Our ref: NO/2024/116104/02-L01
Your ref: 3/2024/0397
Date: 11 July 2024

**APPROVAL OF DETAILS RESERVED BY CONDITIONS 14 (FOUL AND SW DRAINAGE), 16 (SW SUSTAINABLE DRAINAGE STRATEGY), 17 (CONSTRUCTION SW MANAGEMENT PLAN), 18 (OPERATION AND MAINTENANCE MANUAL) AND 20 (COMPENSATORY FLOOD STORAGE) FROM PLANNING PERMISSION 3/2021/0731
ST JAMES C OF E PRIMARY SCHOOL, GREENACRE STREET, CLITHEROE, BB7 1ED.**

SECTION VIEWS

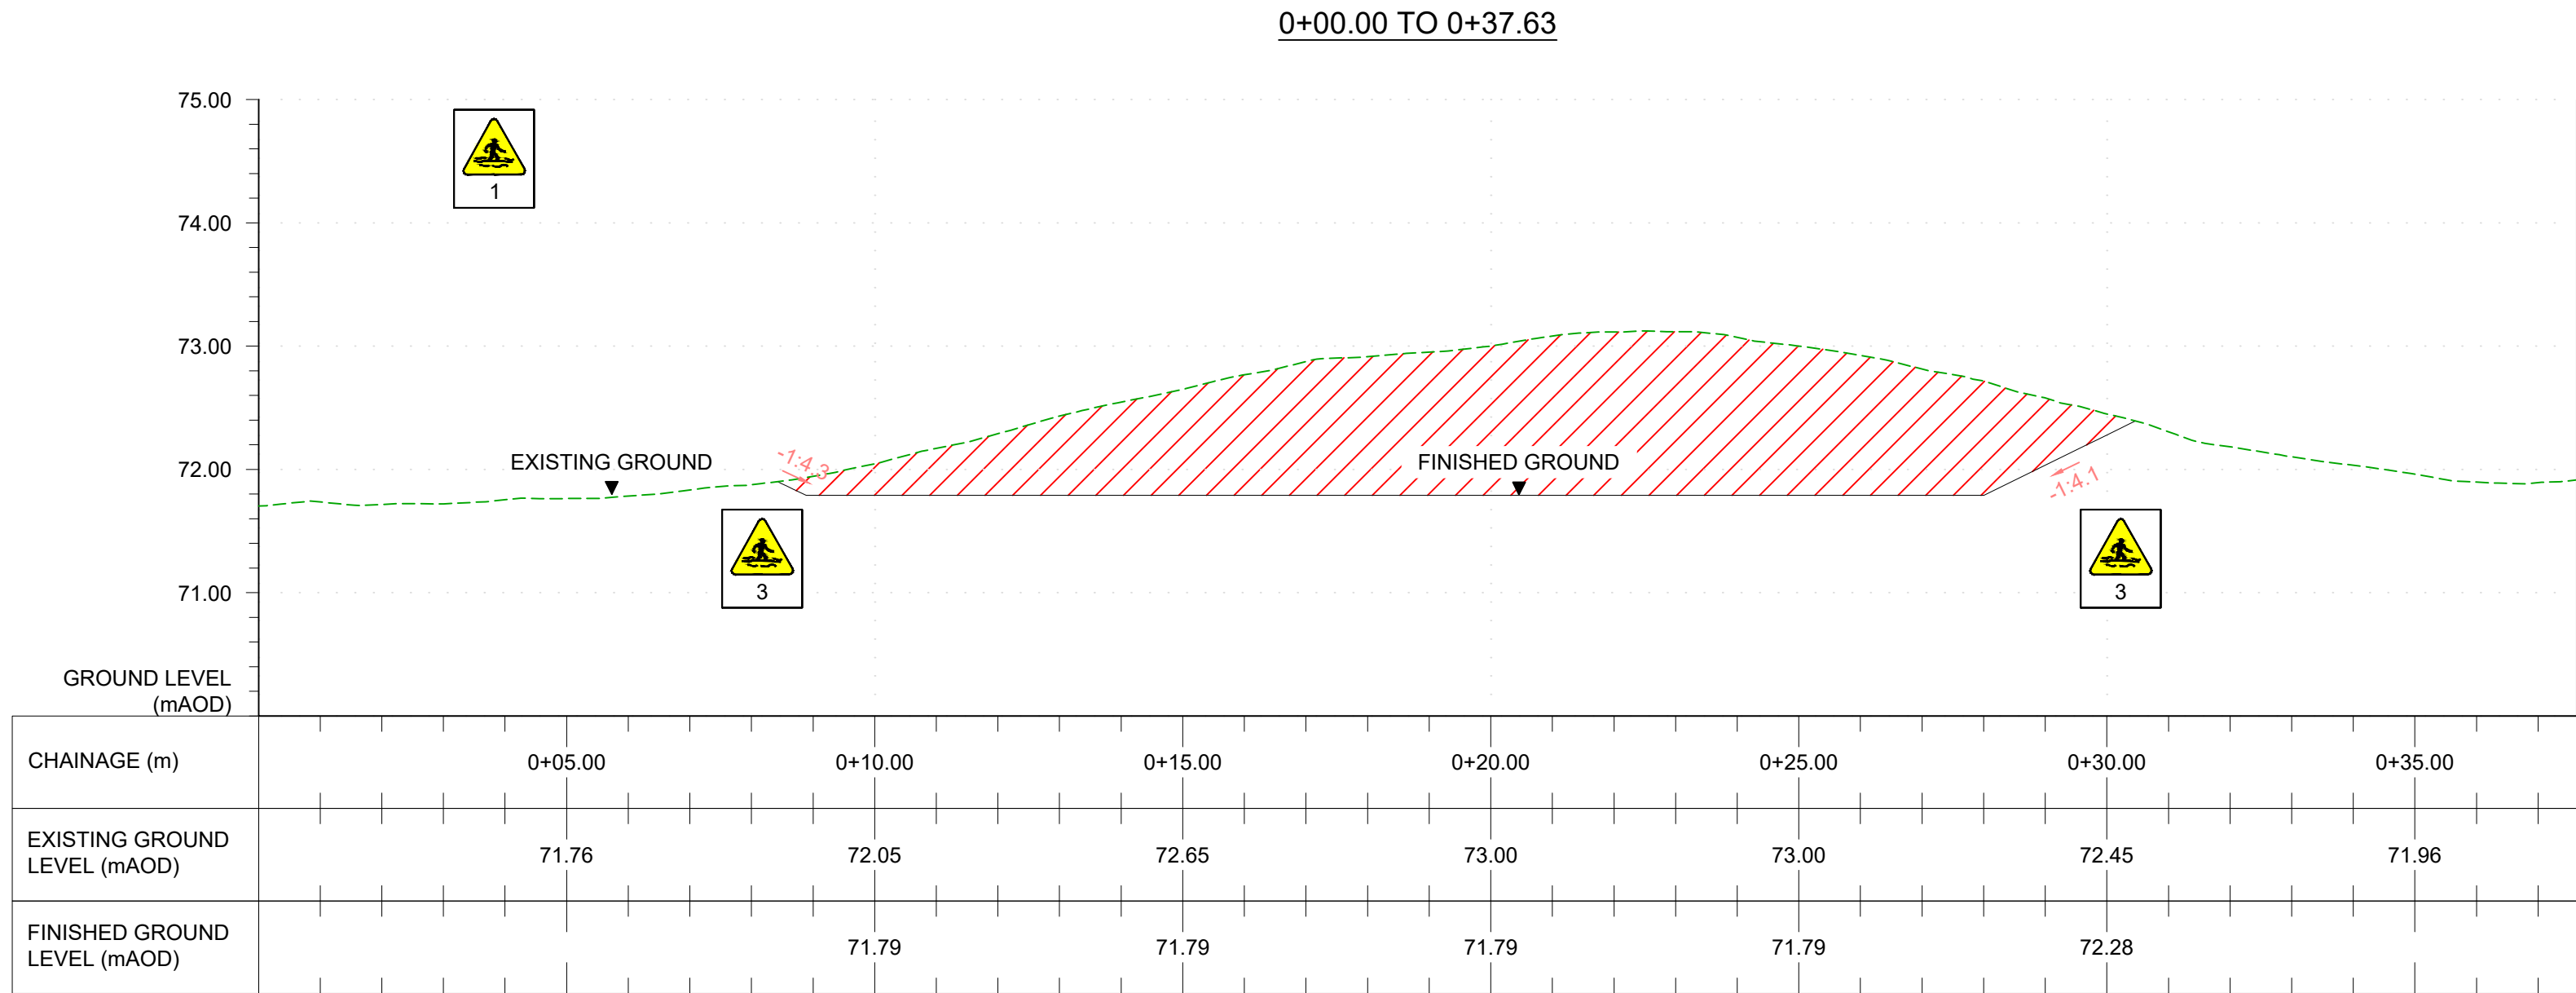
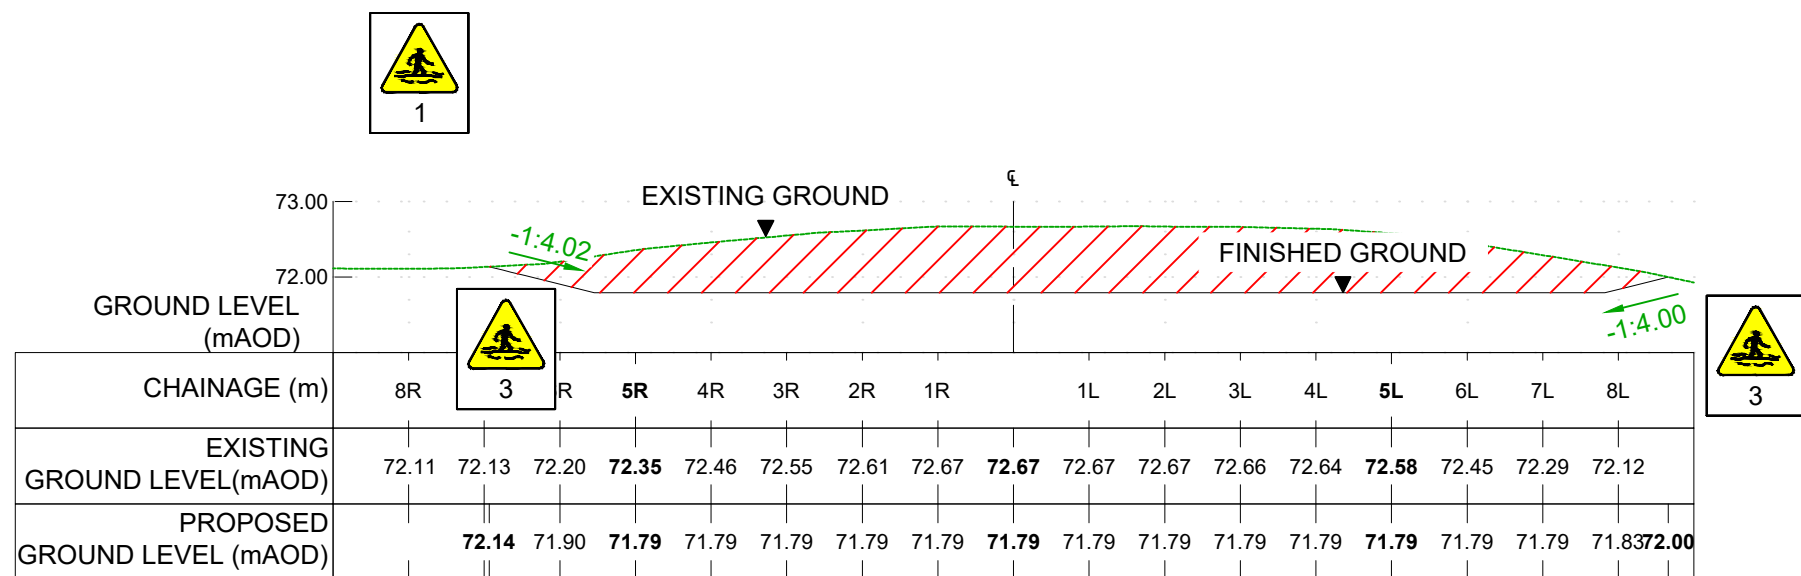
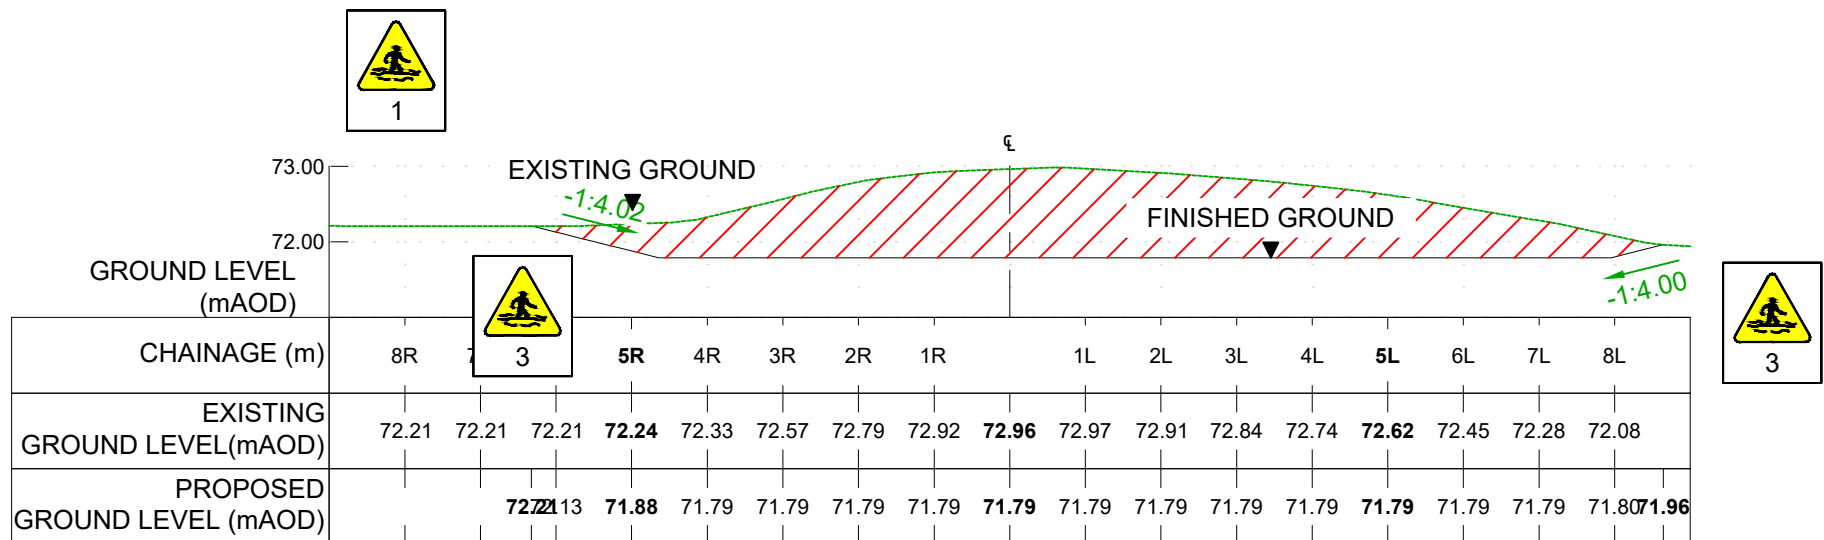
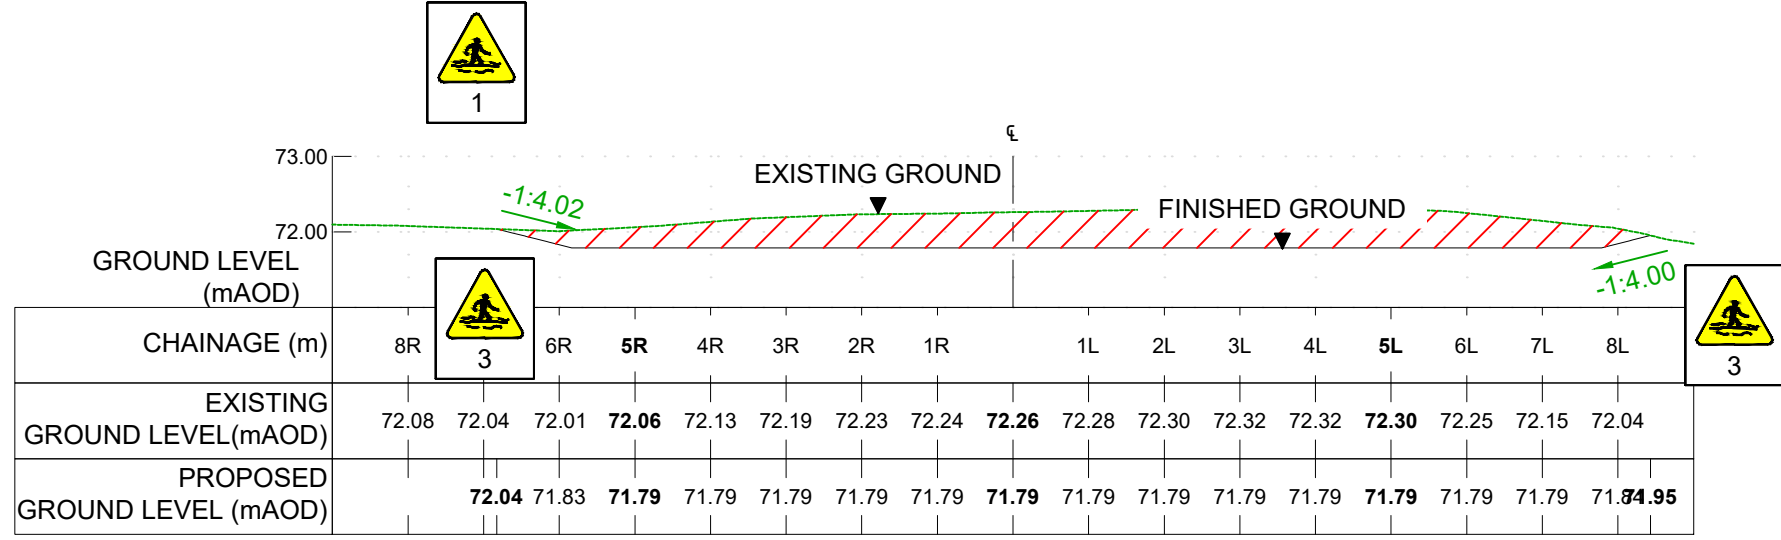
the FRA is currently 'draft' status. We therefore, do not recommend that condition 20 is discharged at this stage until a finalised FRA is submitted together with detailed plans including cross sections for the compensatory flood storage proposals.
